## **BUILDING CODE OF AUSTRALIA 2012 COMMENTS**

### **161 SUSSEX STREET REDEVELOPMENT**

Report Ref: 12025\_R04

Date: 30 May 2012

Drawing Title:	MEZZANINE LEVEL PLAN	REV:	
Drawing Number:	A-DA-0202	REV:	M
Scale:	1:200 @ A0

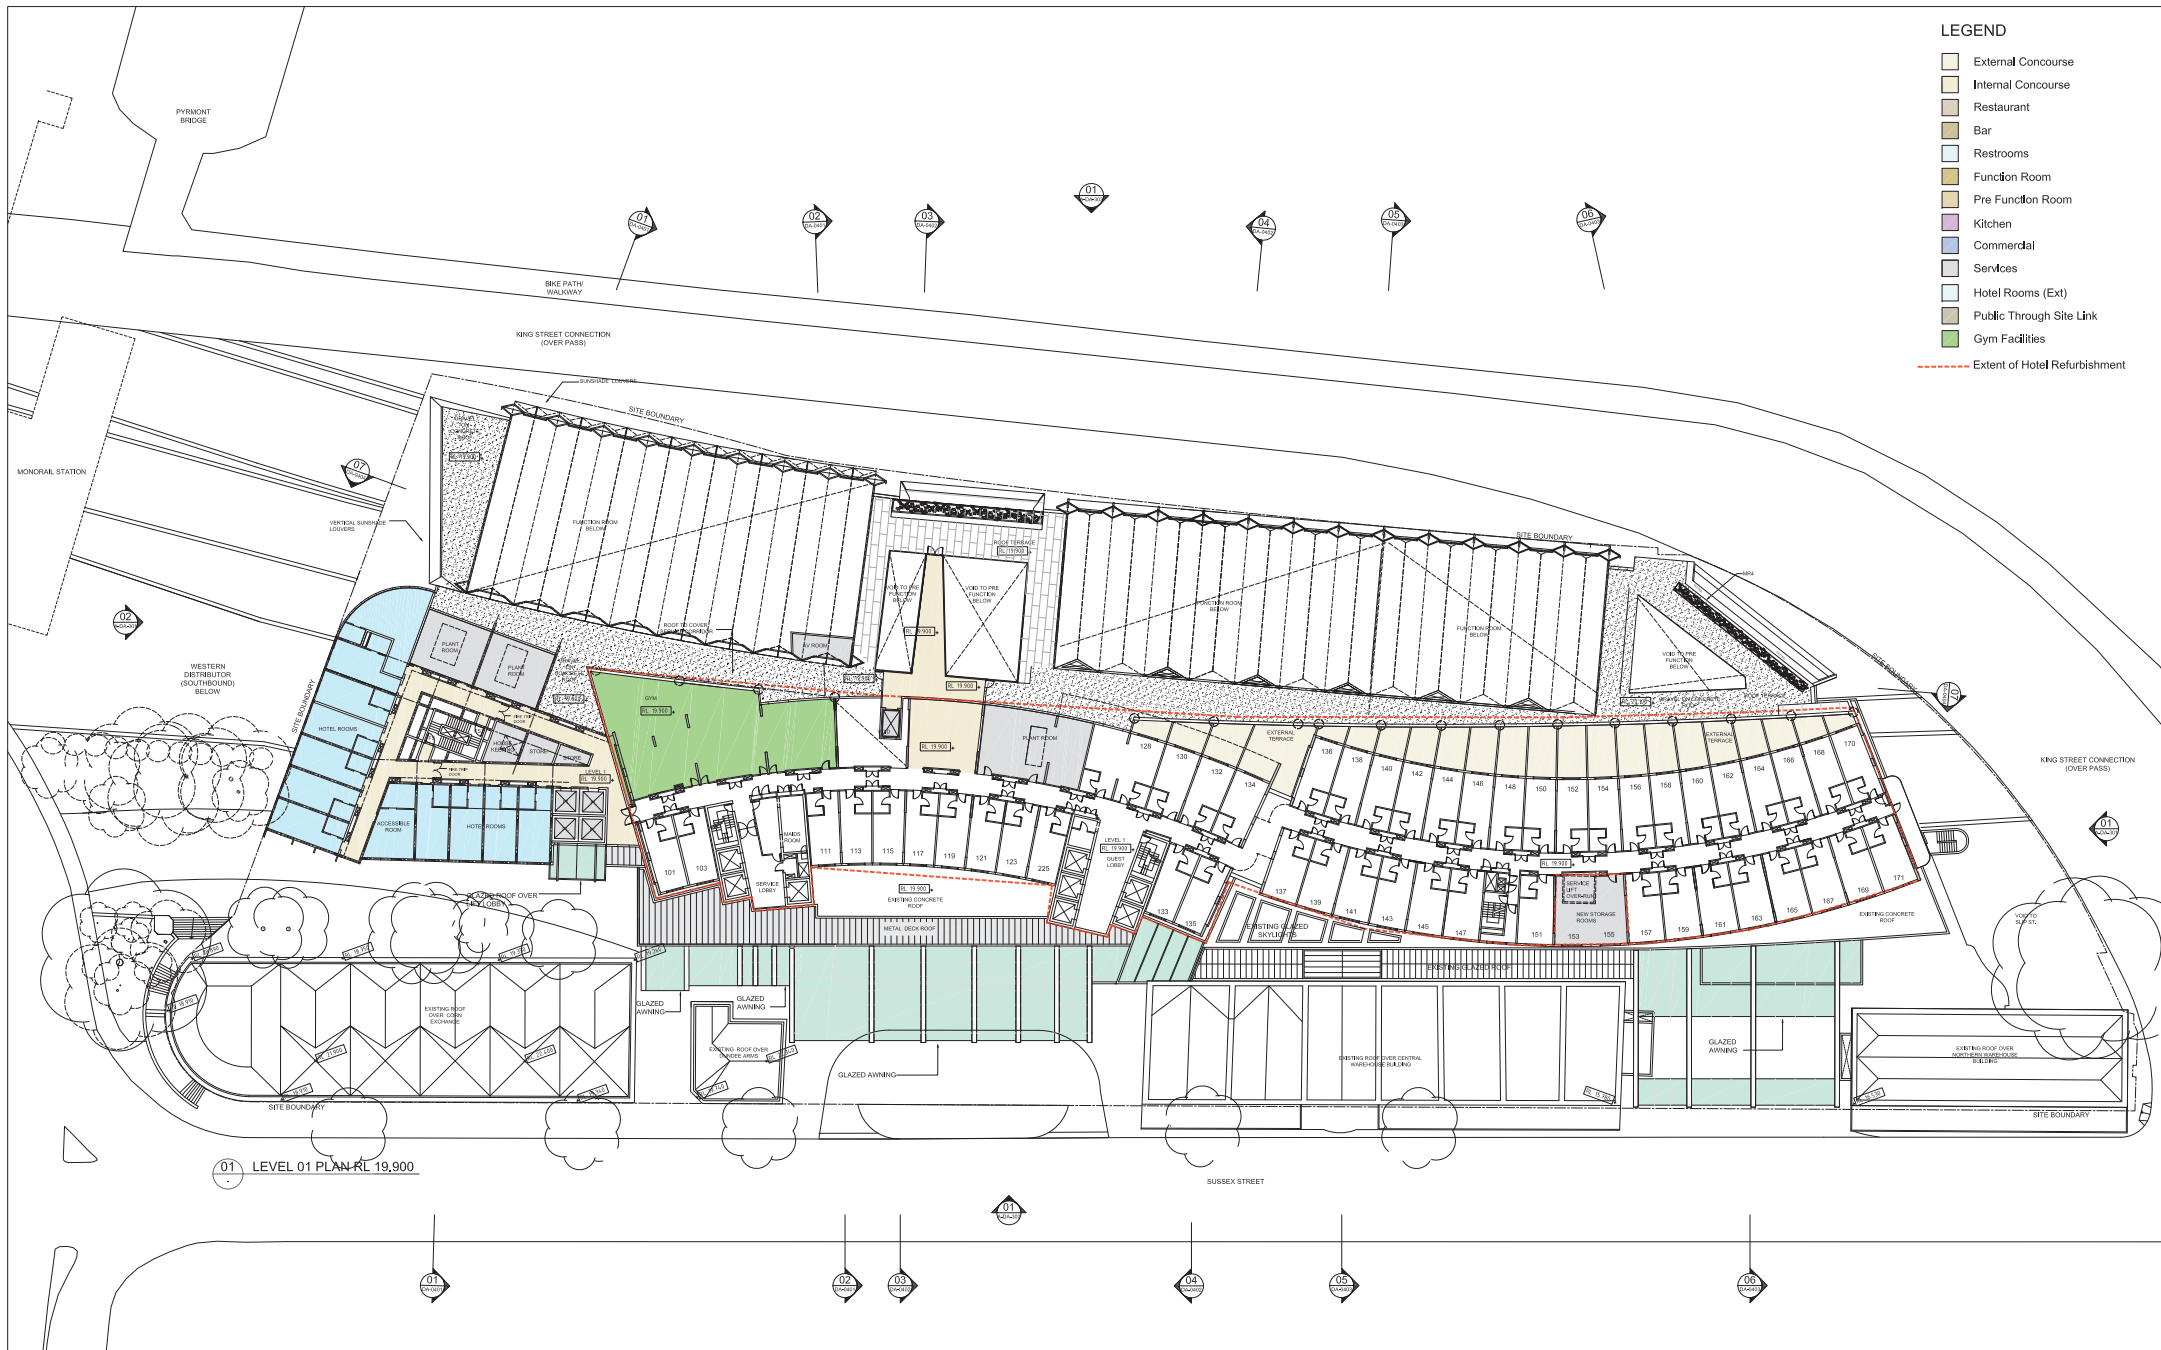
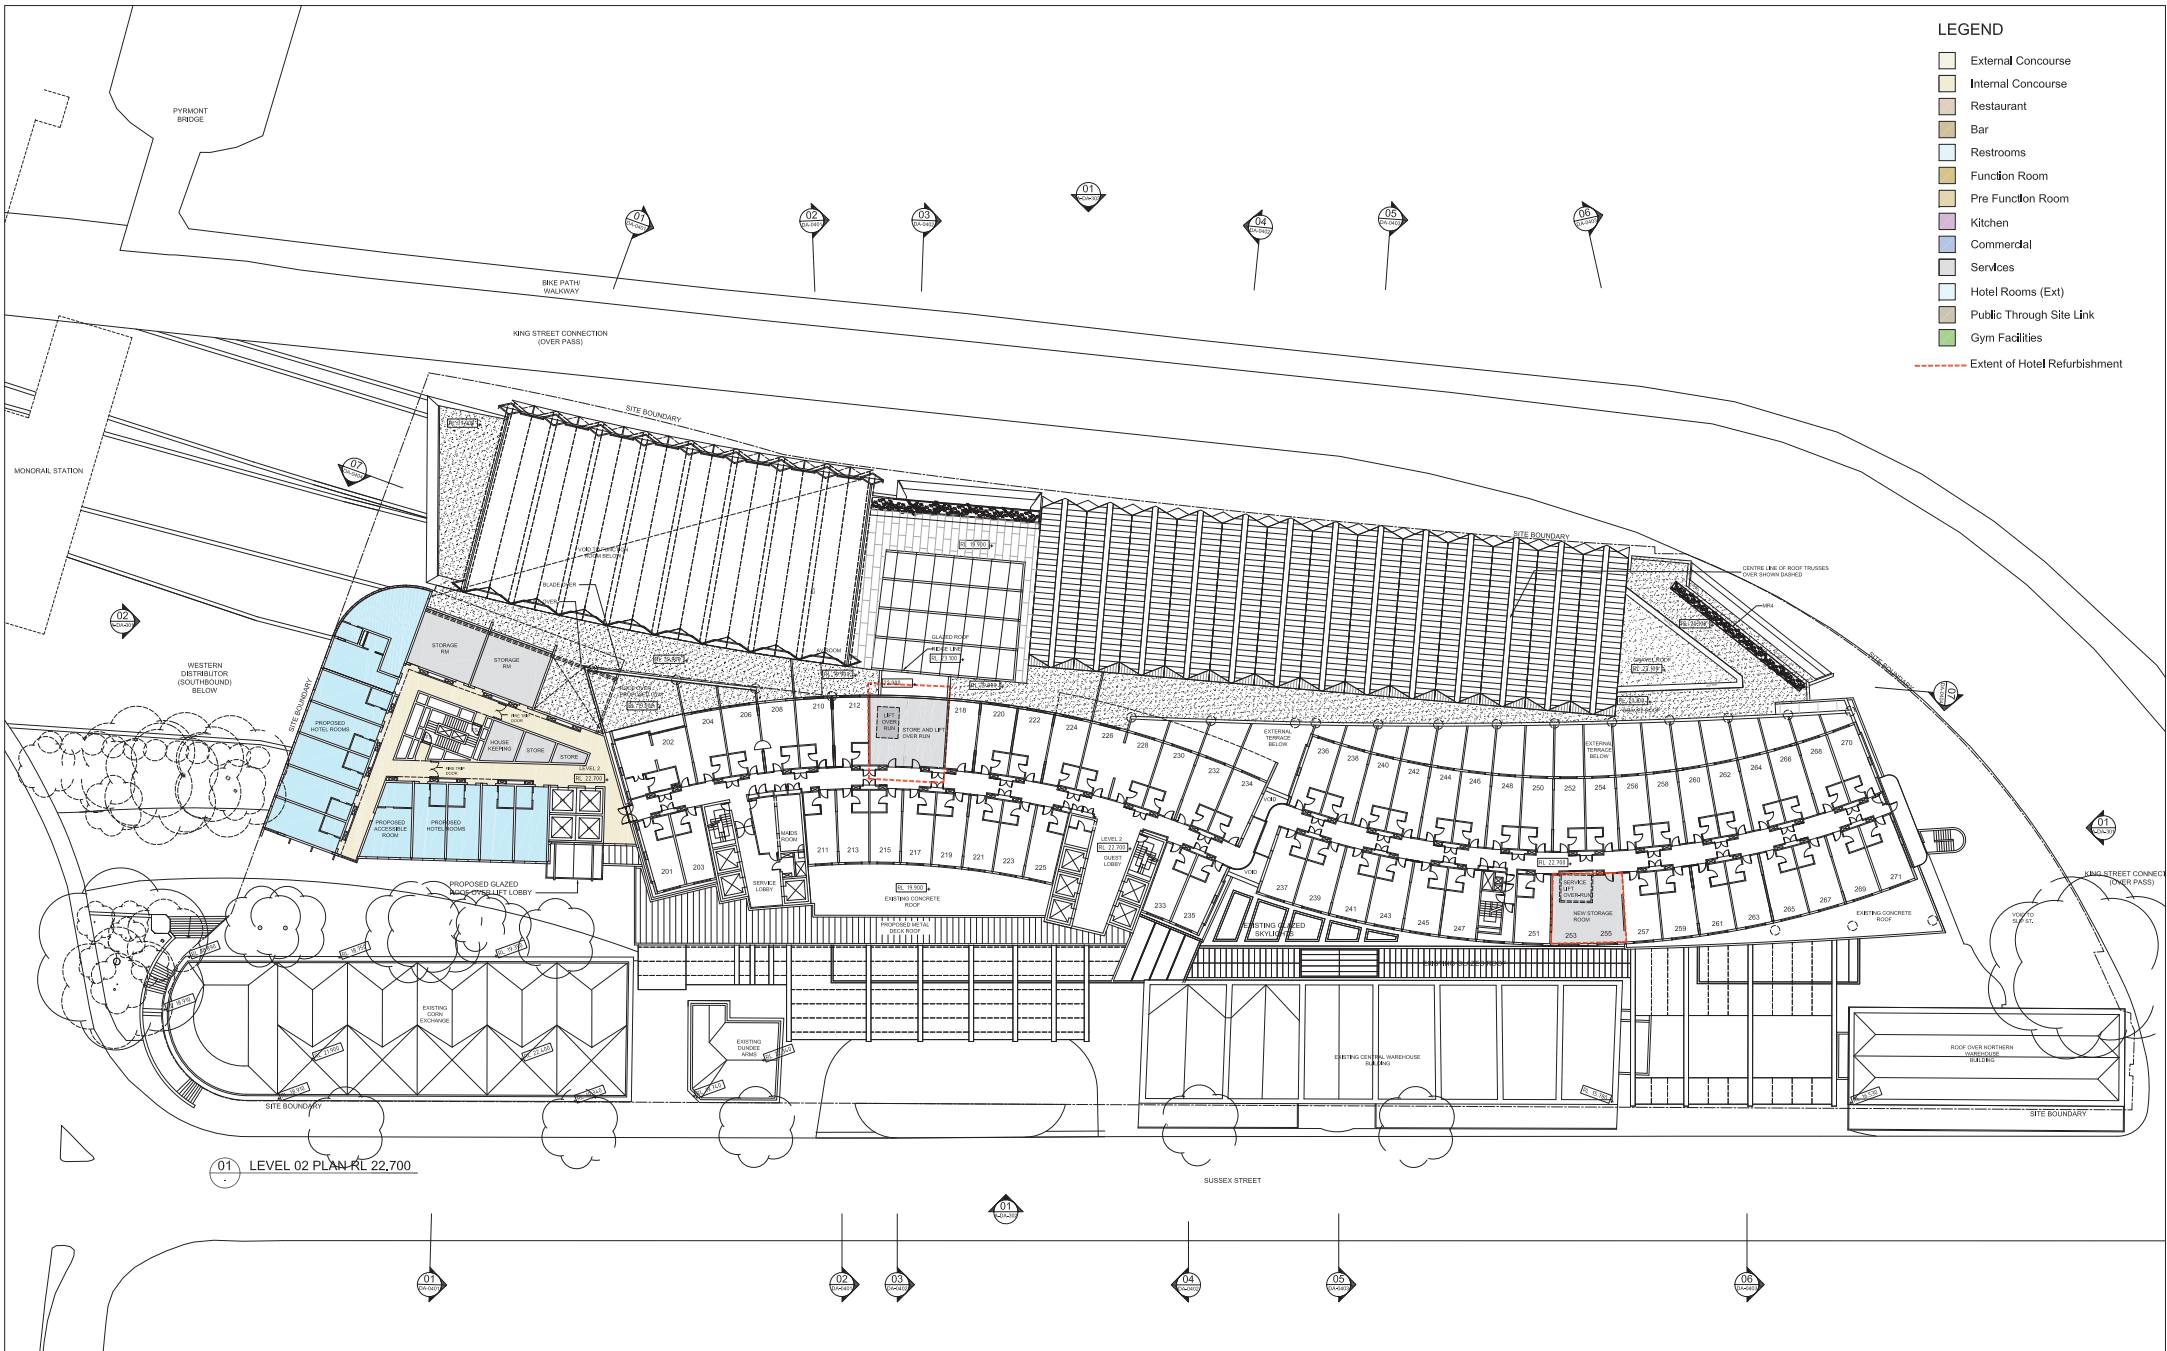
*Lower ground, Ground and Mezzanine levels have a combined fire compartment floor area total of approx 12,000m<sup>2</sup> which exceeds the fire compartment size Type A limits for Class 6 and 9b parts (5000m<sup>2</sup> max). Seek an alternative fire engineered solution or additional means of fire separation.*

*The distance of travel from parts of the meeting rooms at ground level and the function rooms at Mezzanine level is up to 60m to a single exit in lieu of 40m.*

*At ground and mezzanine levels, the travel distances between alternative exits to the north west part of the are up to 87m in lieu of 60m max.*

*With the Construction Certificate, amendments will be required to show doorways to the proposed Ground level staff cafeteria, production kitchen, storage area and plant rooms and at Mezzanine level to the Function room area, servery kitchen, chillers and back of house area all in the new south end.*

- Ground Level = approx 2345 persons. A minimum of 24m aggregate exit width required. *(approx 30m provided)*
- Mezzanine Level = approx 2606 persons. *A minimum of 26m of exit width required. Only 20m of exit width is available – does not comply. An alternative solution will be required.*
- Commercial Levels 16-21 has approx 820m<sup>2</sup> of office space / 10 = 82 persons. A minimum 1m of exit width required. At least 2m is available – complies.
- A 1m clear path of travel must be retained throughout the building and in all exit paths – compliance readily achievable

Drawing Title: **LEVEL 04 TO LEVEL 10 TYPICAL FLOOR PLAN**
 Drawing Number: **A-DA-0206**
 Scale: **1:200 @ A0**

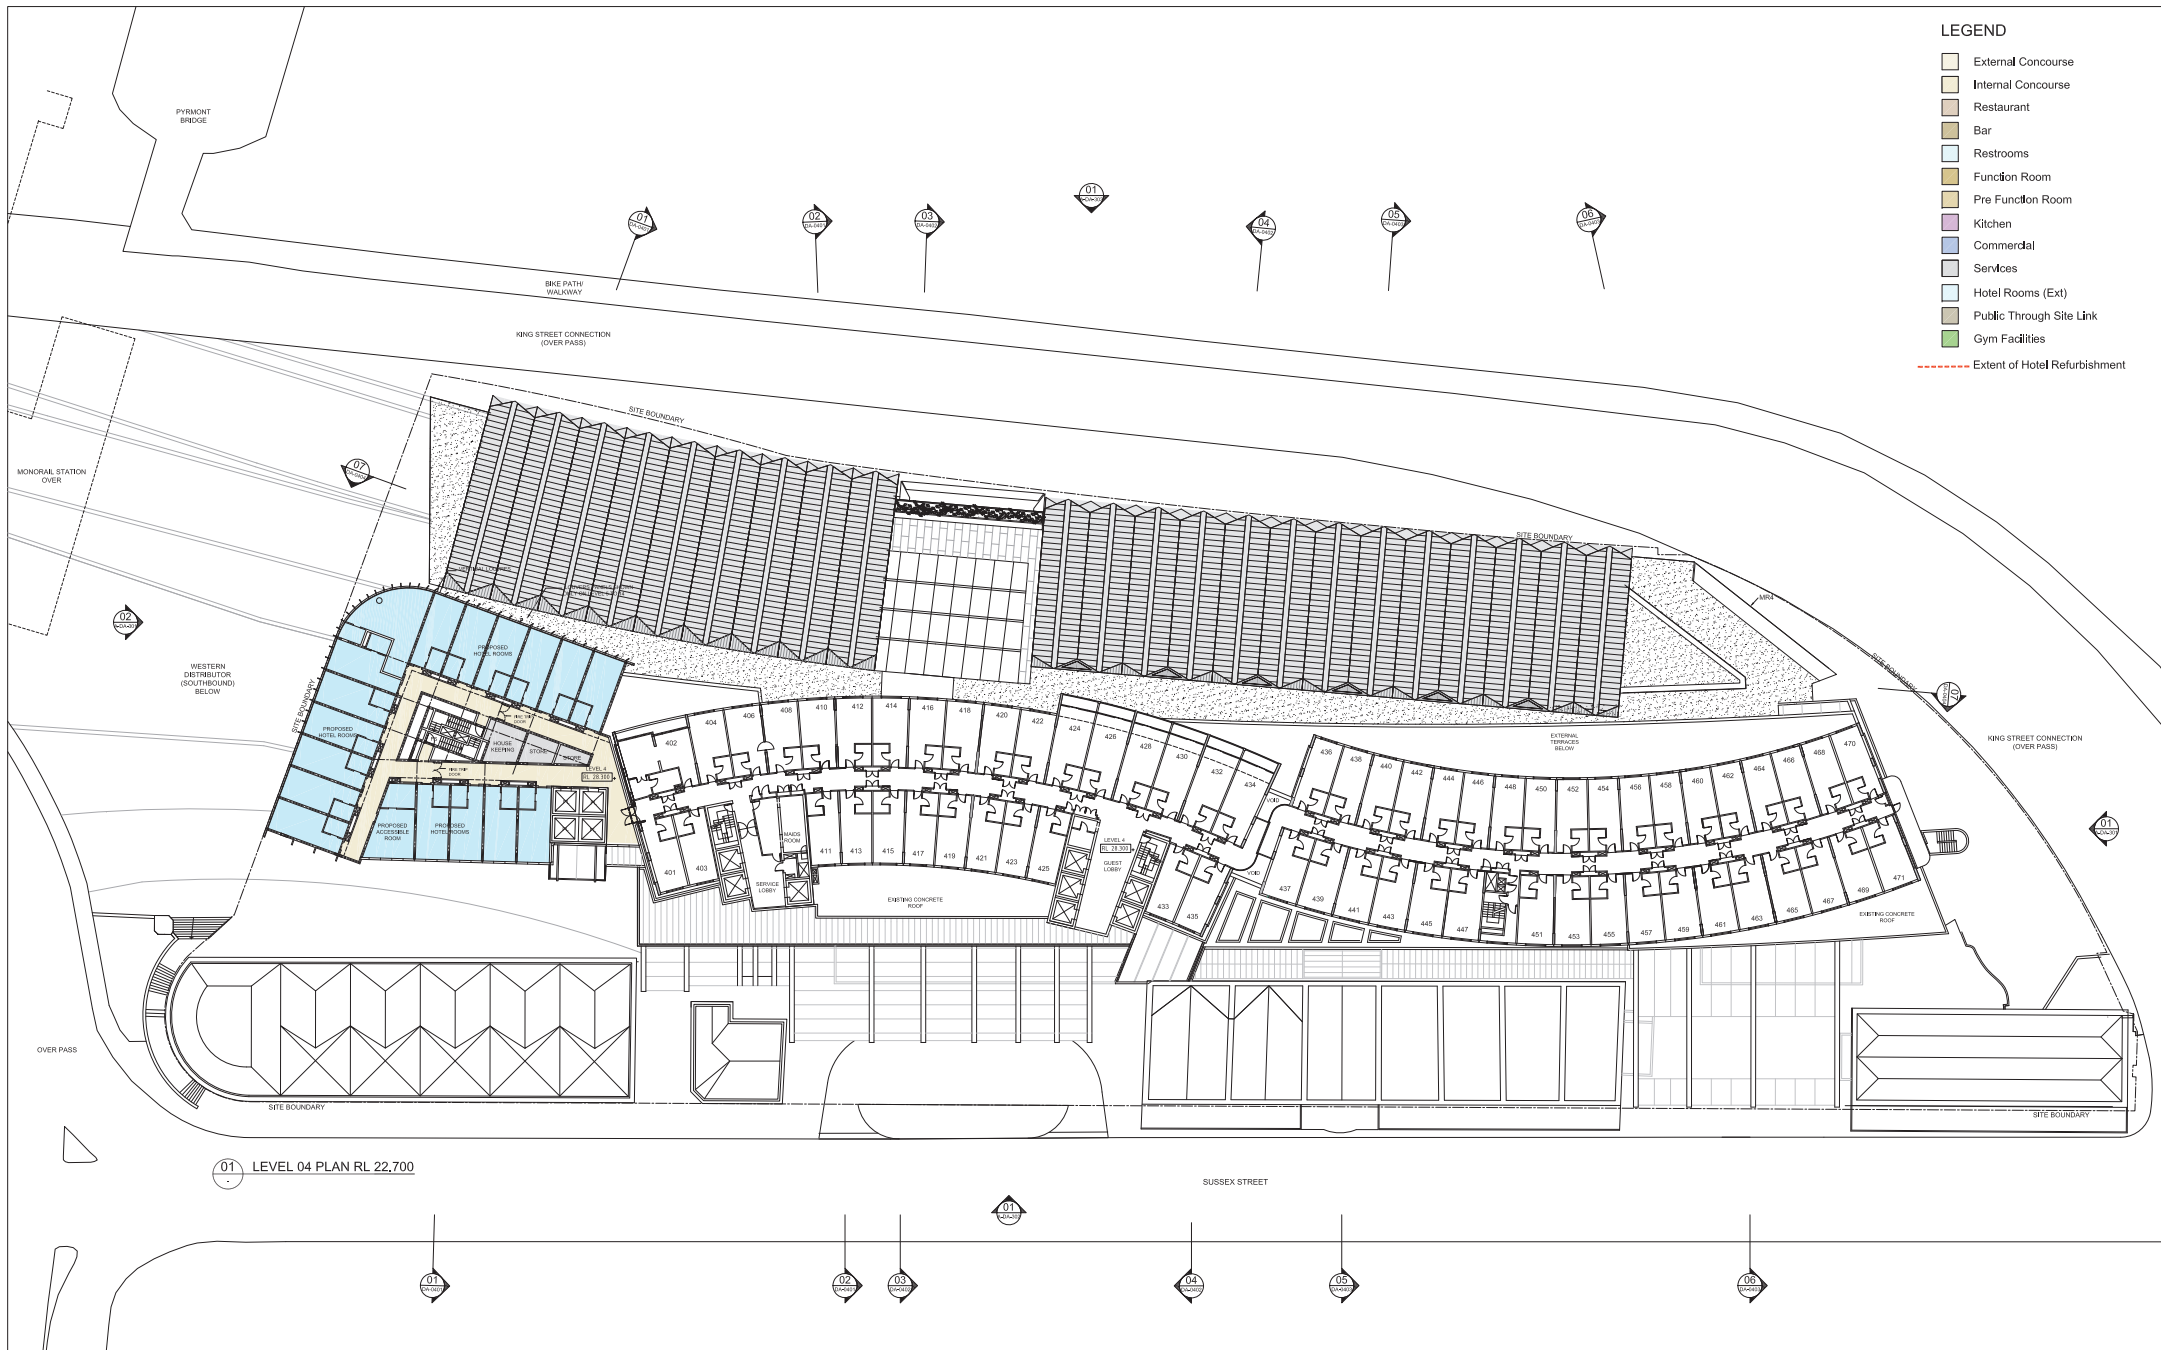
- The party walls between residential levels sole occupancy units to be not less than 90/90/90 Fire Resistance Level (FRL) or -/60/60 if non-loadbearing. Class 3 Suites structural slabs and columns to be 90/90/90 FRL.
- *The current length of the existing public corridors on Levels 1 to 10 without smoke partitioning is up to 160m in lieu of 40m maximum contrary to Clause C2.14 – Upgrading will likely be required.*
- *The length of public corridors on new south end extension Levels 1 to 14 without smoke partitioning is up to 70m in lieu of 40m maximum contrary to Clause C2.14.*

*Travel distances do not comply to Levels 4-14 residential levels in the SE corner of the new tower extension having 10m to a point of choice in lieu of 6m. Seek fire engineered alternative solution.*
